Response to Submissions Report

State Significant Development – SSD 18_9095

Armidale High School Redevelopment

Butler Street, Armidale

The carpark in the foreground is screened by new landscaping.

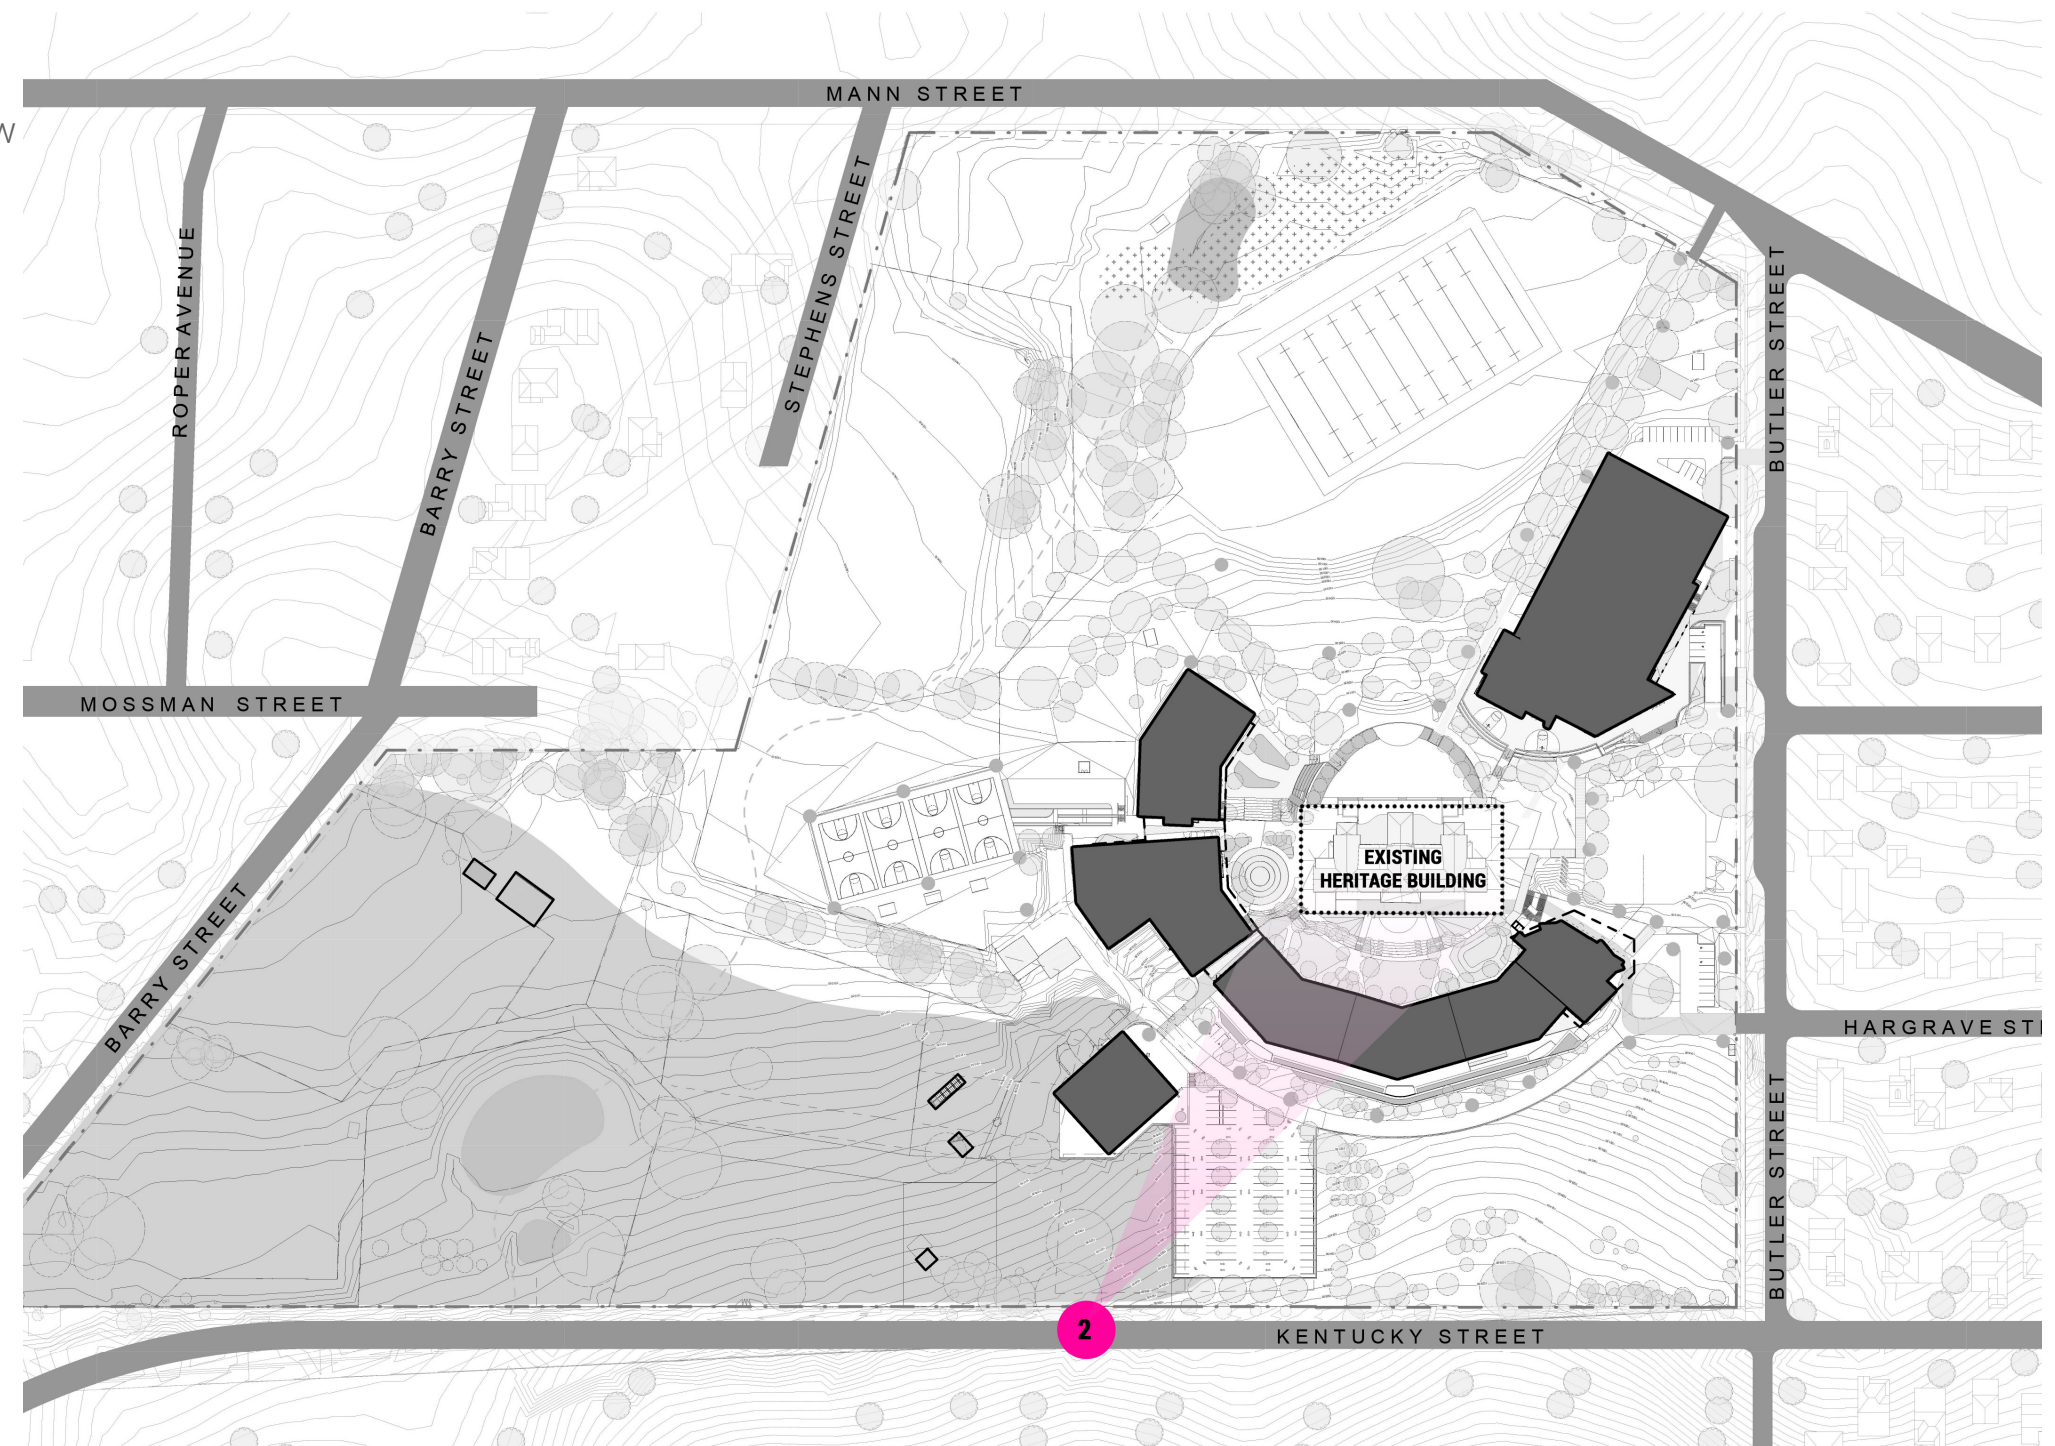
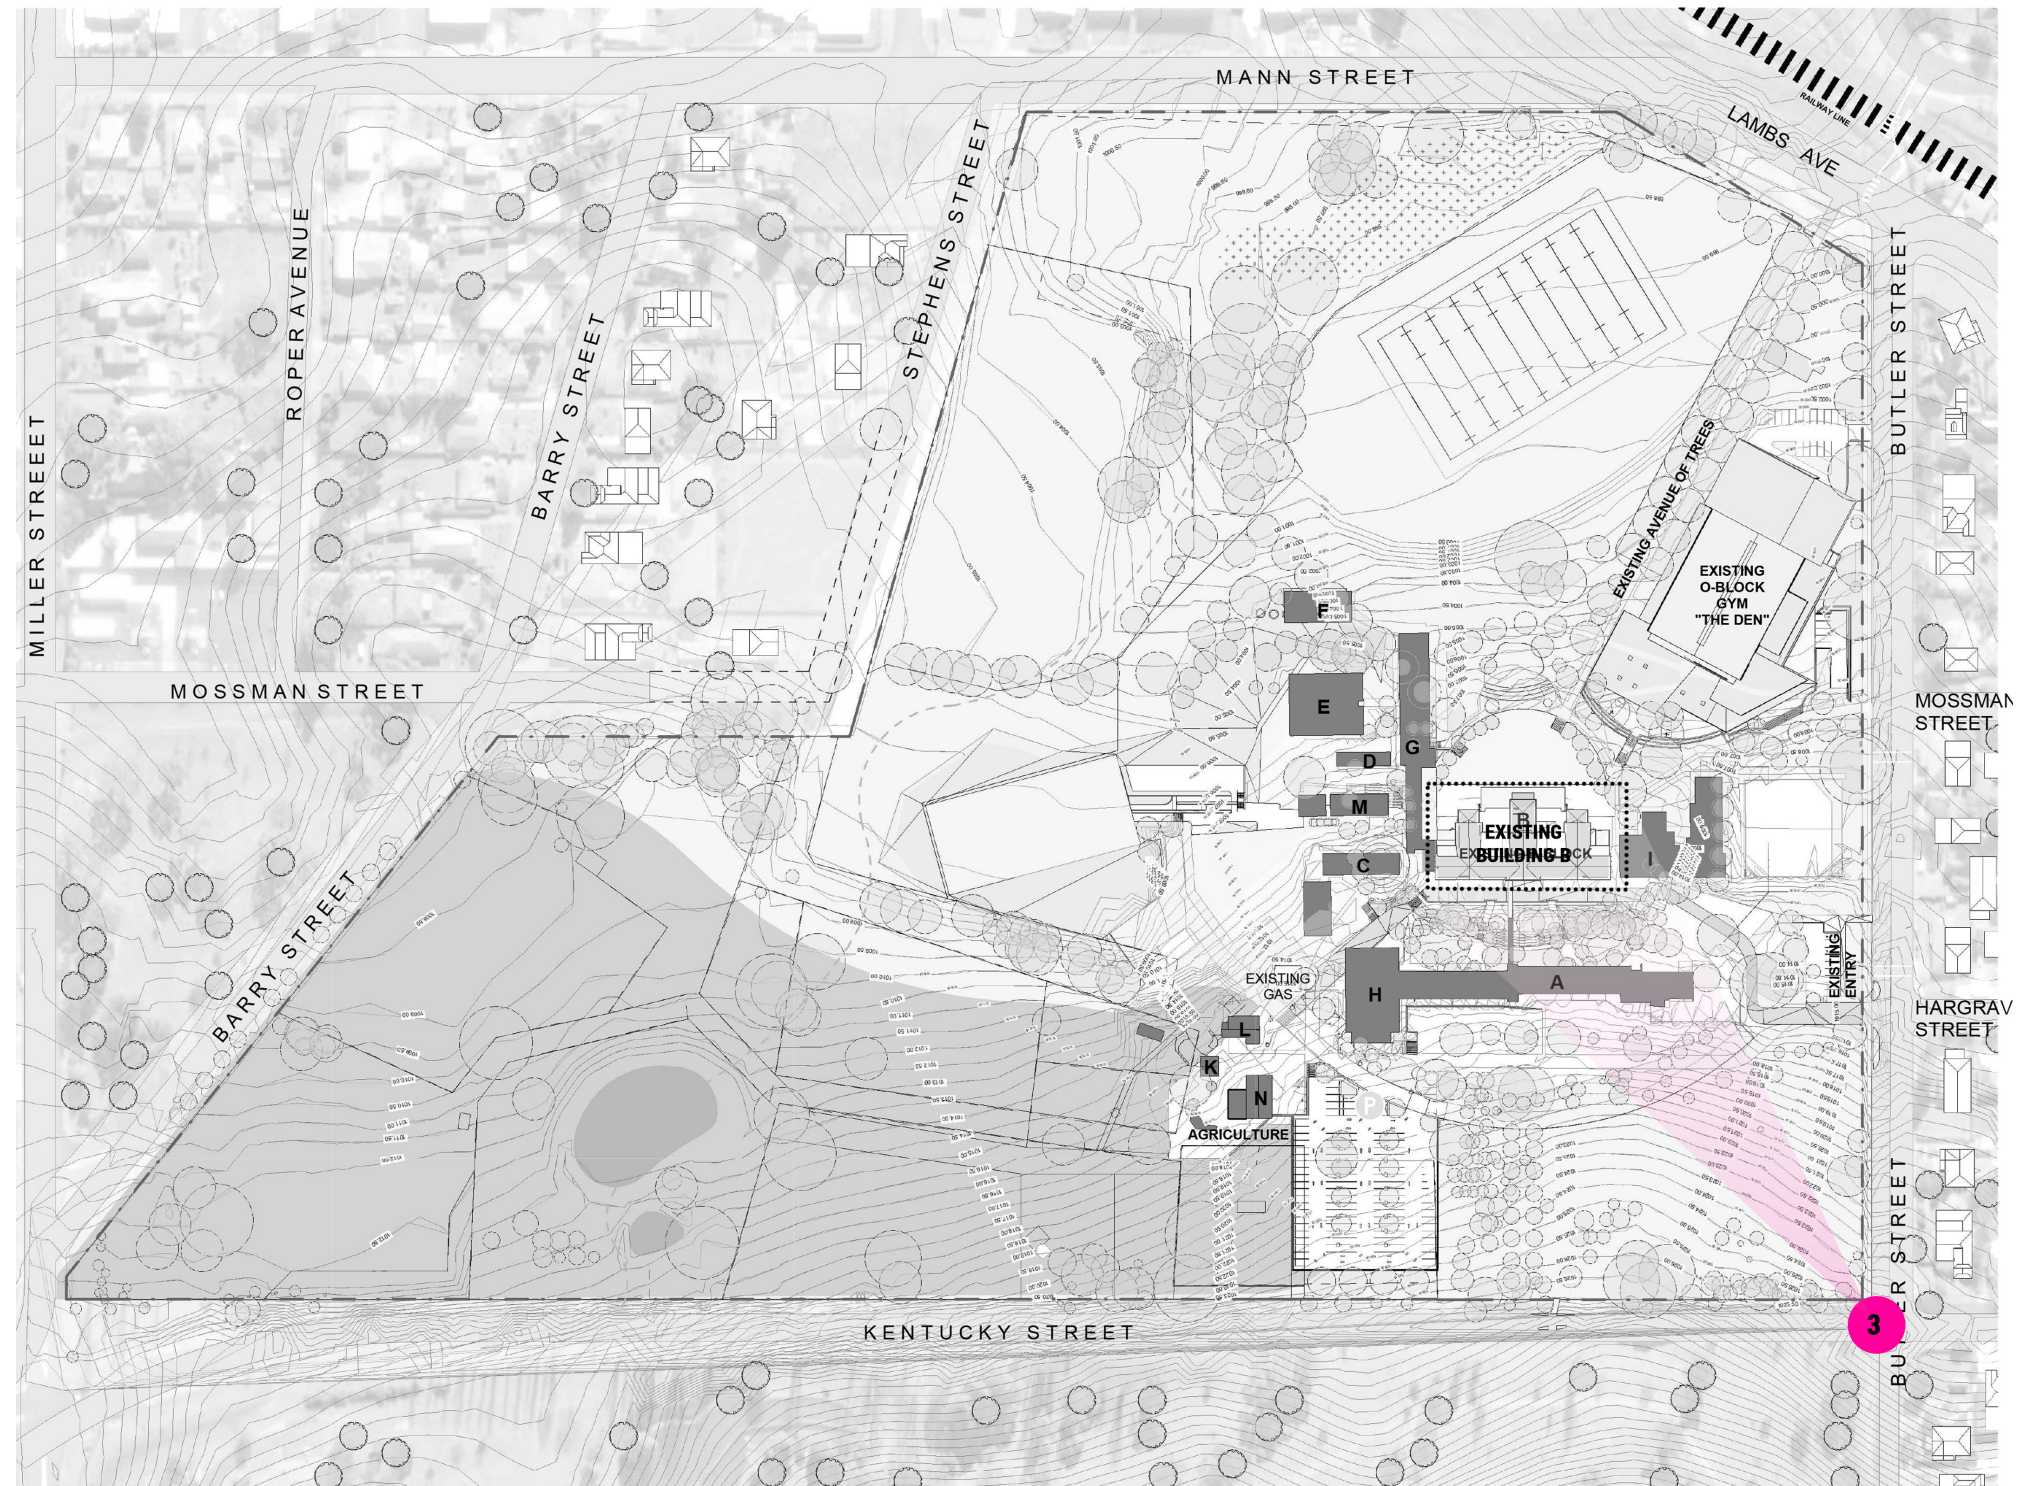
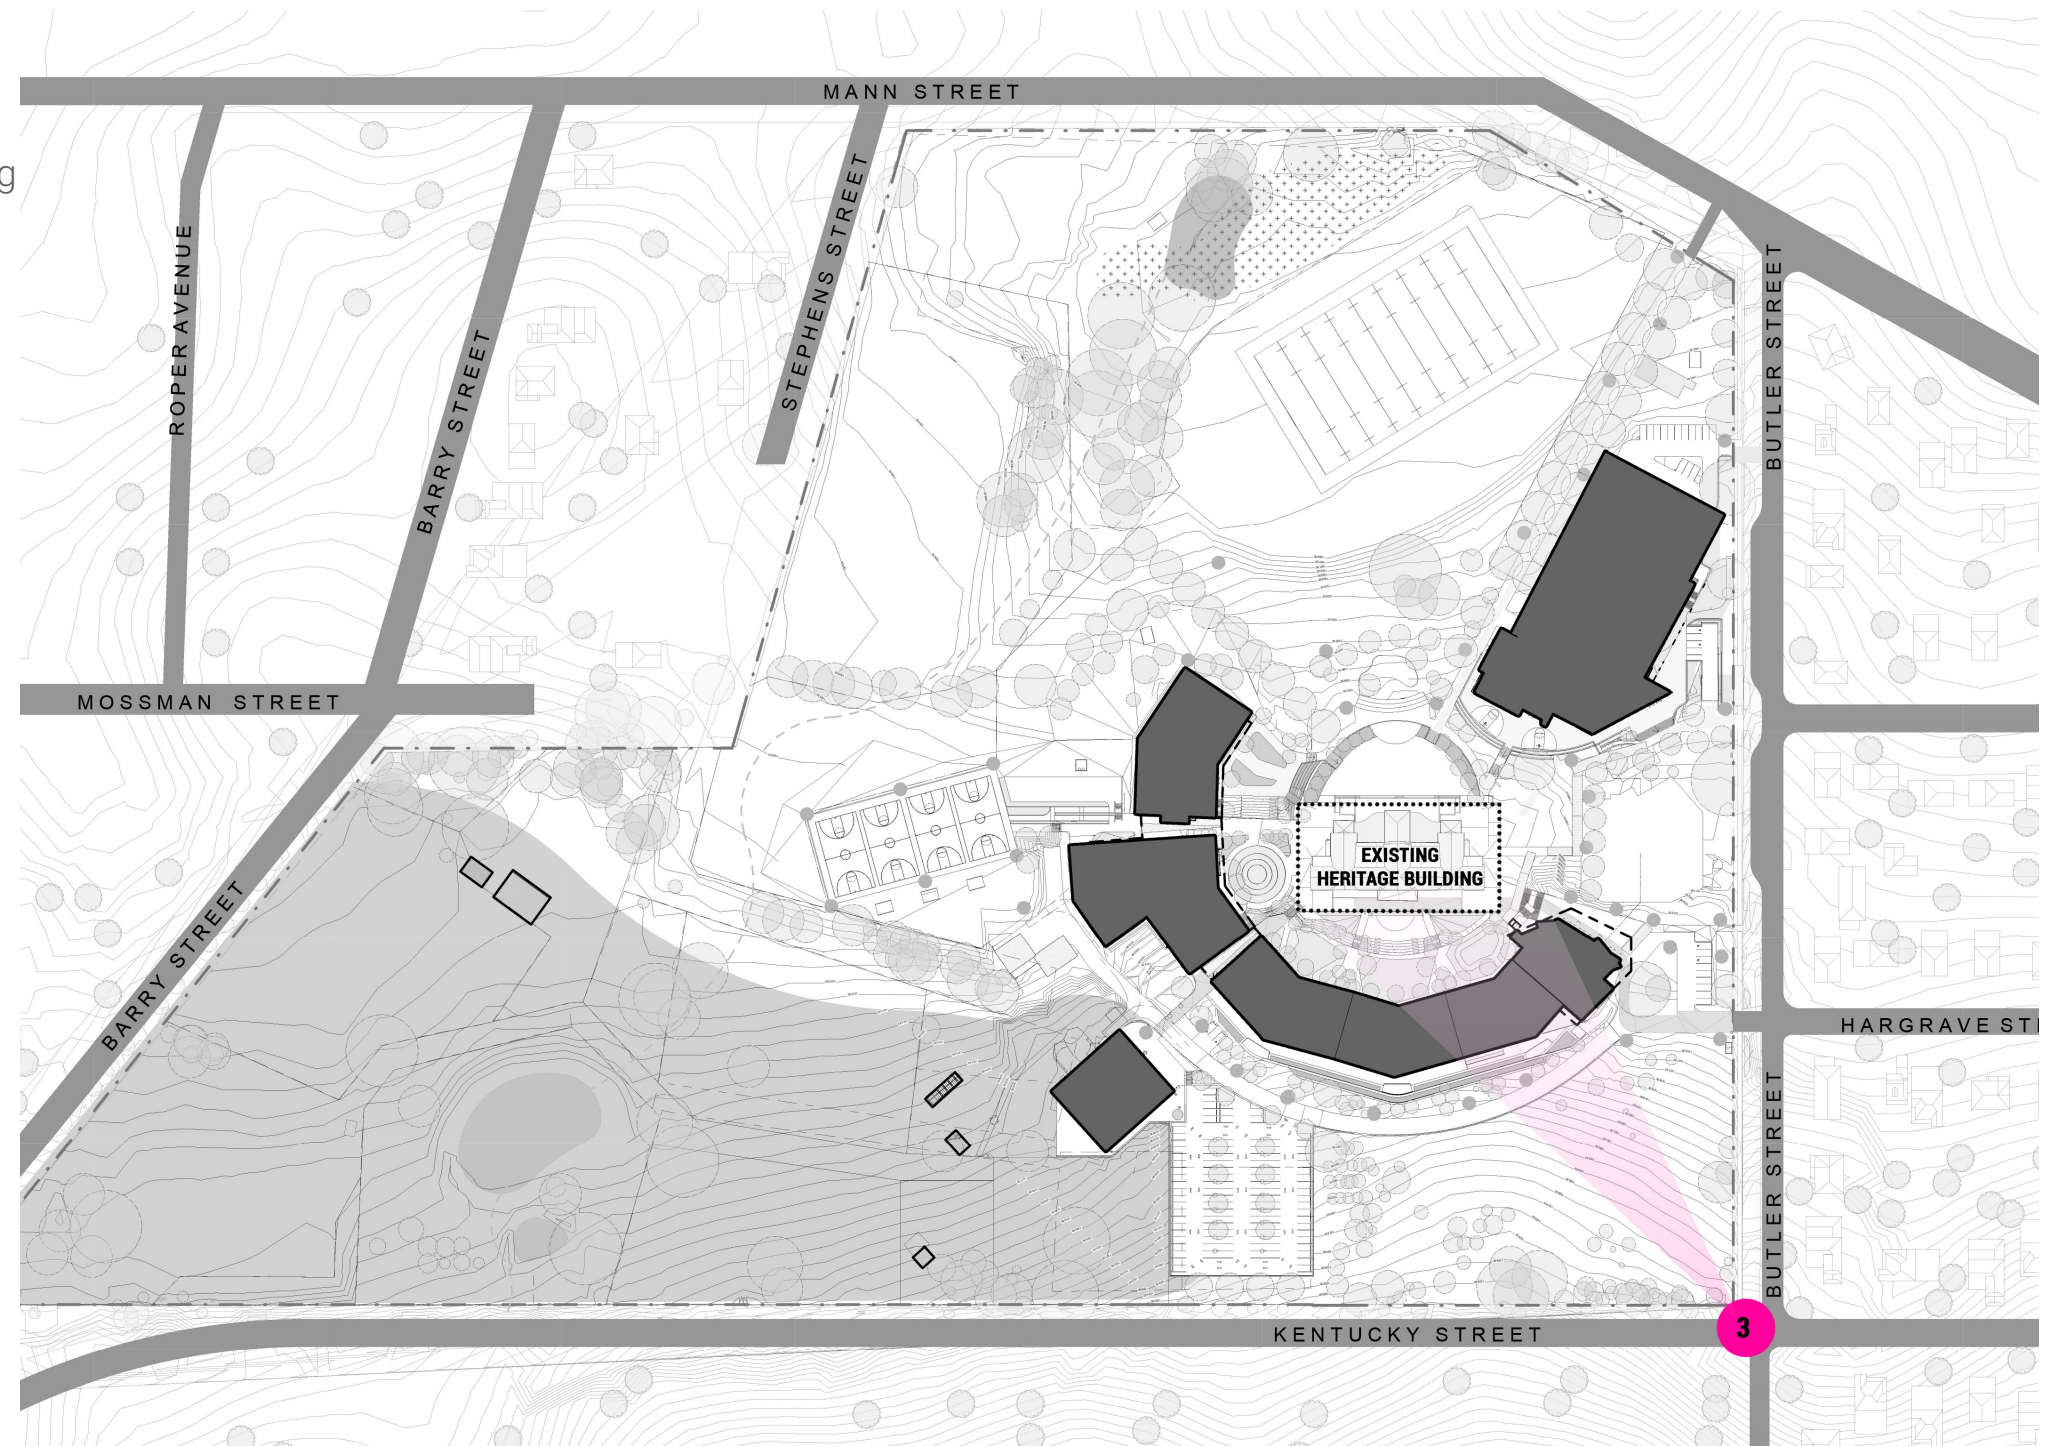
7. While it is acknowledged the Council did not raise concerns with regard to the proposed development, the Heritage Council has raised concern with regard to the impact of the proposal on significant views to the locally listed heritage item. Additional information is required addressing the impact of the proposal on the significant views.	The View Analysis provided as part of the original DA submission (refer Appendix 16 of the EIS) has been updated to provide additional information, including: - Comparison between existing and proposed views at significant viewpoints around the site; - Demonstration as to how these views would be maintained with the construction of the proposed buildings; and - Consideration of the impact the proposed buildings would have on significant views, including potential improvement to views or prominence of visual settings within the site. Further, it is noted that the design change to accommodate air conditioning (resulting in an increase in building height by 300mm) has been incorporated into the expanded View Analysis.	View Analysis Appendix 2
